**City of Portland, Maine - Building or Use Permit Application**  
 389 Congress Street, 04101 Tel: (207) 874-8703, Fax: (207) 874-8716

<b>Permit No:</b> 06-1427	<b>Issue Date:</b>	<b>CBL:</b> 406 F058001
------------------------------	--------------------	----------------------------

<b>Location of Construction:</b> 22 STEPPING STONE LN Lot 8	<b>Owner Name:</b> KING CONSTRUCTION CORP	<b>Owner Address:</b> 198 SACO AVE	<b>Phone:</b>
<b>Business Name:</b>	<b>Contractor Name:</b> King Construction Corp	<b>Contractor Address:</b> 198 Saco OOB	<b>Phone</b> 2079347622
<b>Lessee/Buyer's Name</b>	<b>Phone:</b>	<b>Permit Type:</b> Single Family	<b>Zone:</b>

**Dept:** Zoning      **Status:** Approved with Conditions      **Reviewer:** Ann Machado      **Approval Date:** 10/10/2006  
**Note:** **Ok to Issue:**

LOT 8 - GRADING PLAN
 AUTUMN GLEN SUBDIVISION

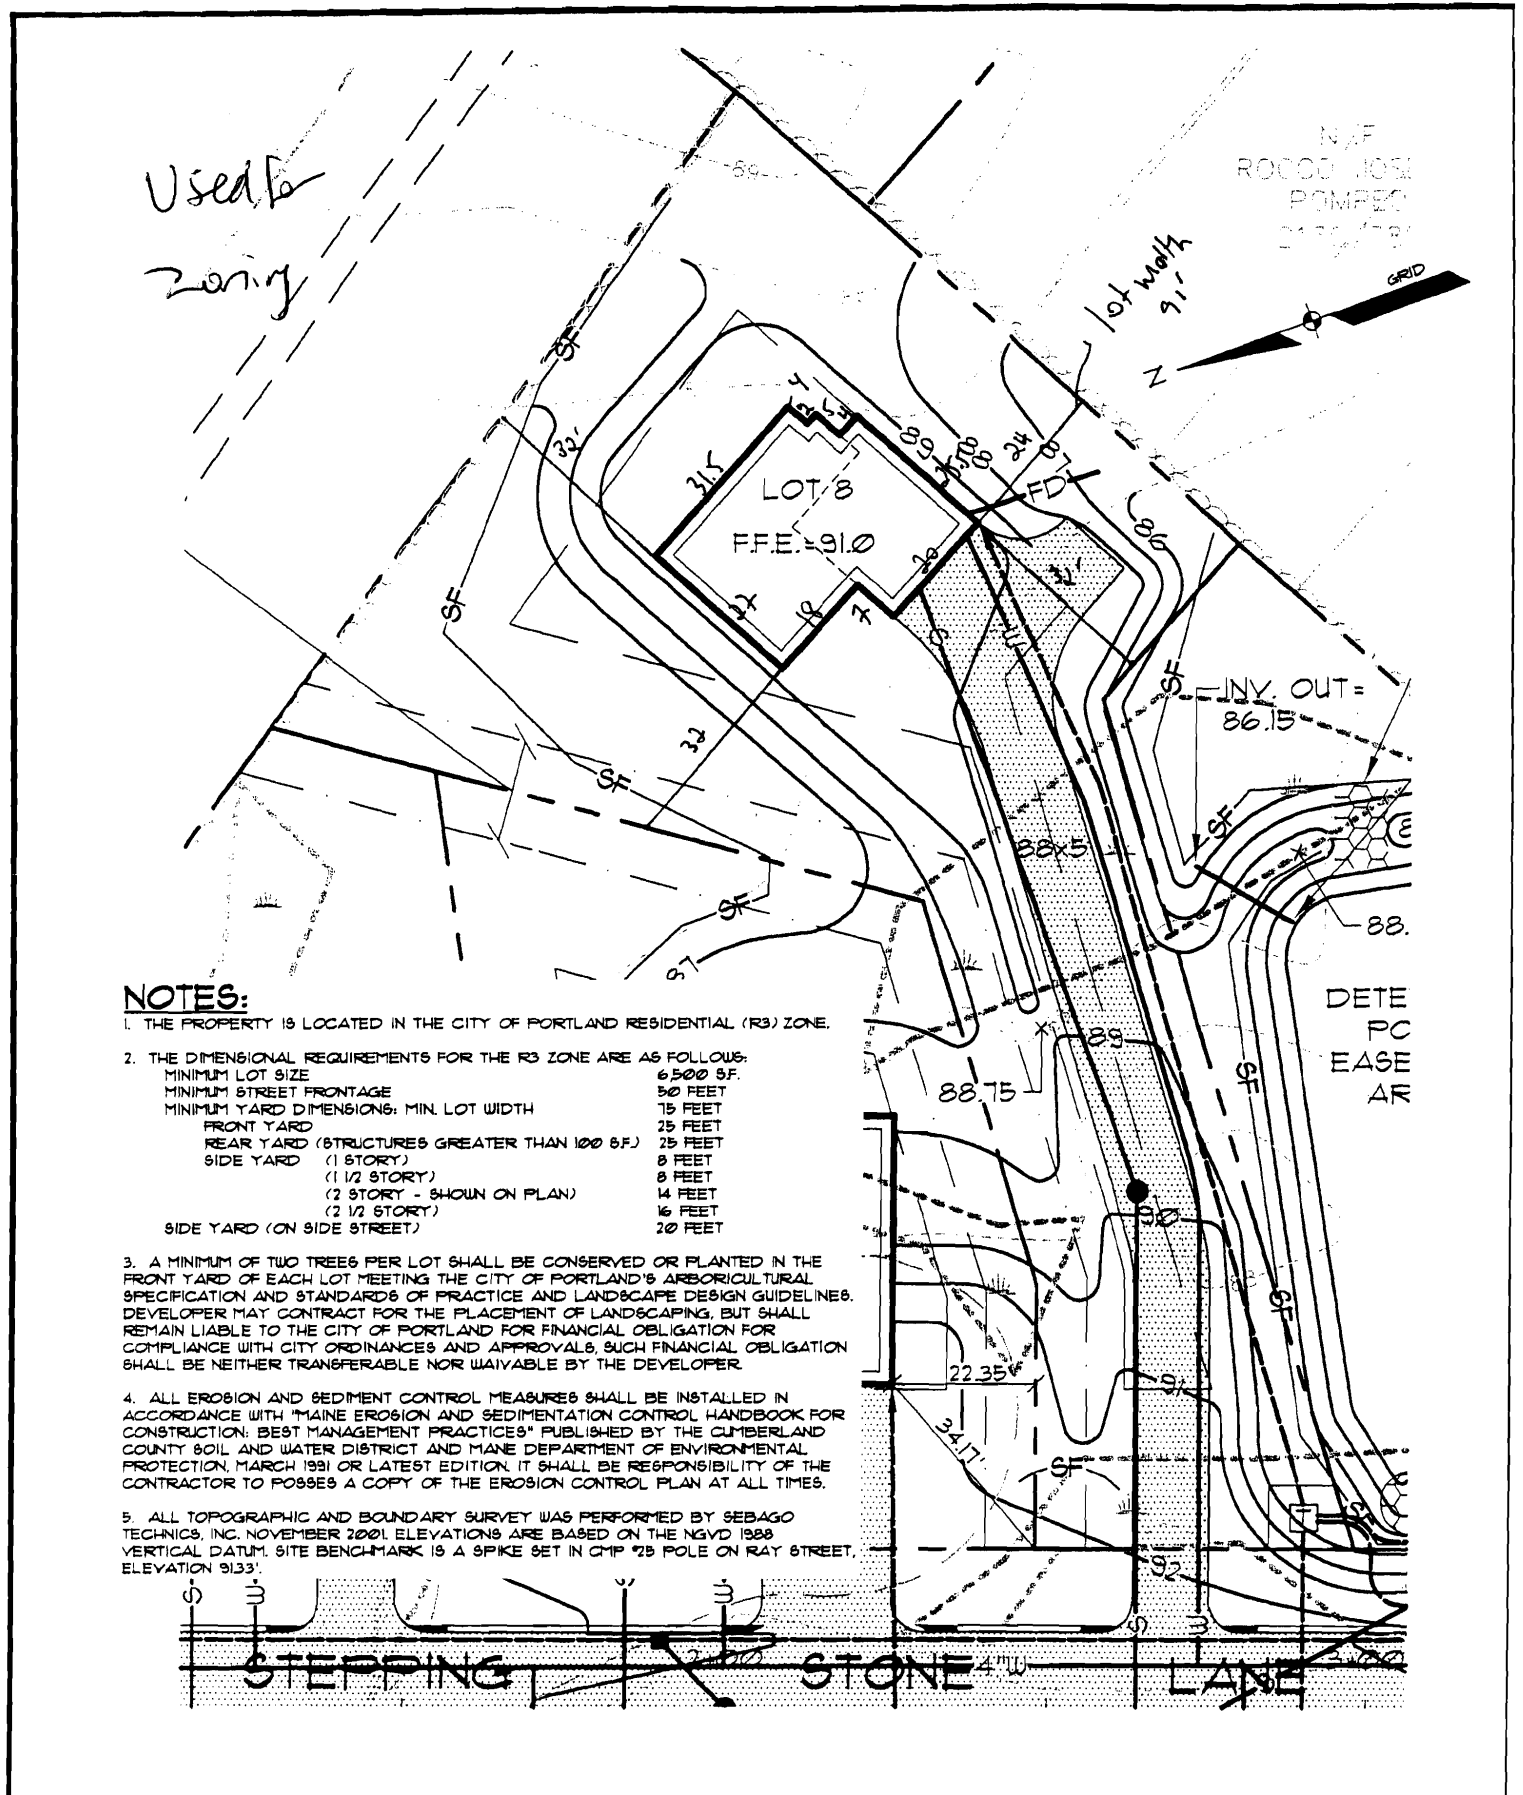
10/4/2006-amachado: Elevation plans show a daylight basement in the rear. This does not match with the grading plan. Left message for King Weinstein to call me.  
11/2/2006-tmm: finished reviews of all permits - left message for King  
11/16/2006-tmm: re-reviewed info submitted - plans still lack a large amount of info - called KRE  
1/12/2007-tmm: rec'd additional info - of to issue w/conditions.

1 STAIR SECTION

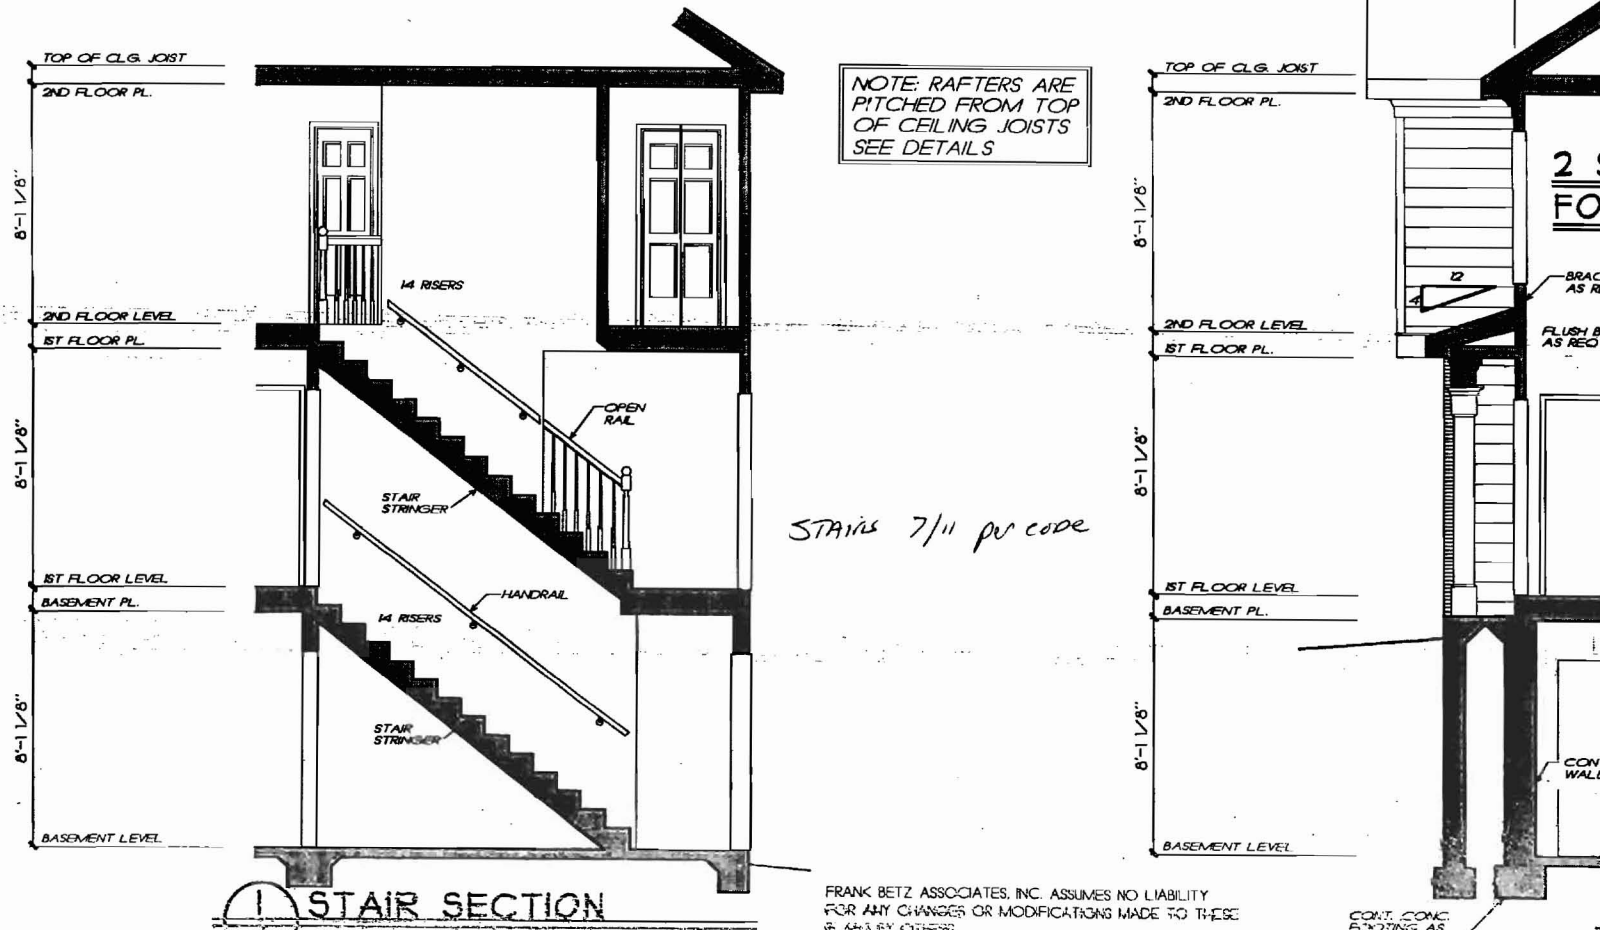
- 1) Permit approved based on the plans submitted and reviewed w/owner/contractor, with additional information as agreed on and as noted on plans.
- 2) There must be a 2" clearance maintained between the chimney and any combustible material, with draft stopping per code at each level

ROOF FRAMING

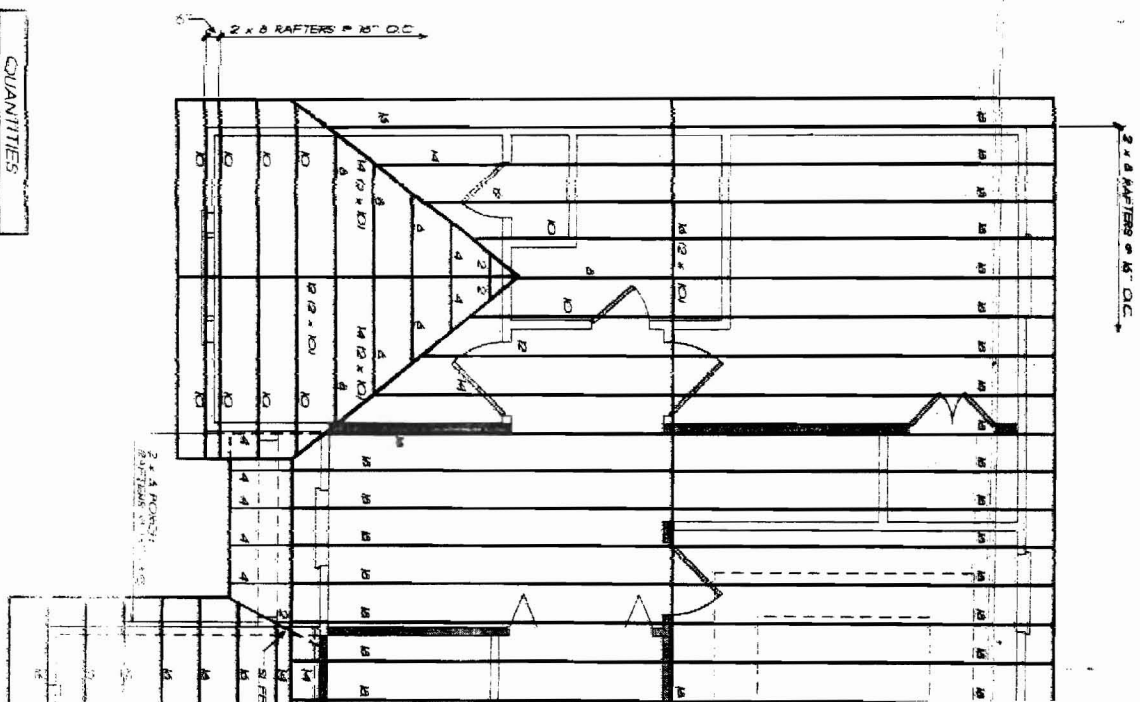
- 5) Hardwired interconnected battery backup smoke detectors shall be installed in all bedrooms, protecting the bedrooms, and on every level.
- 6) As discussed, the rafters must be 2" x 10"s.
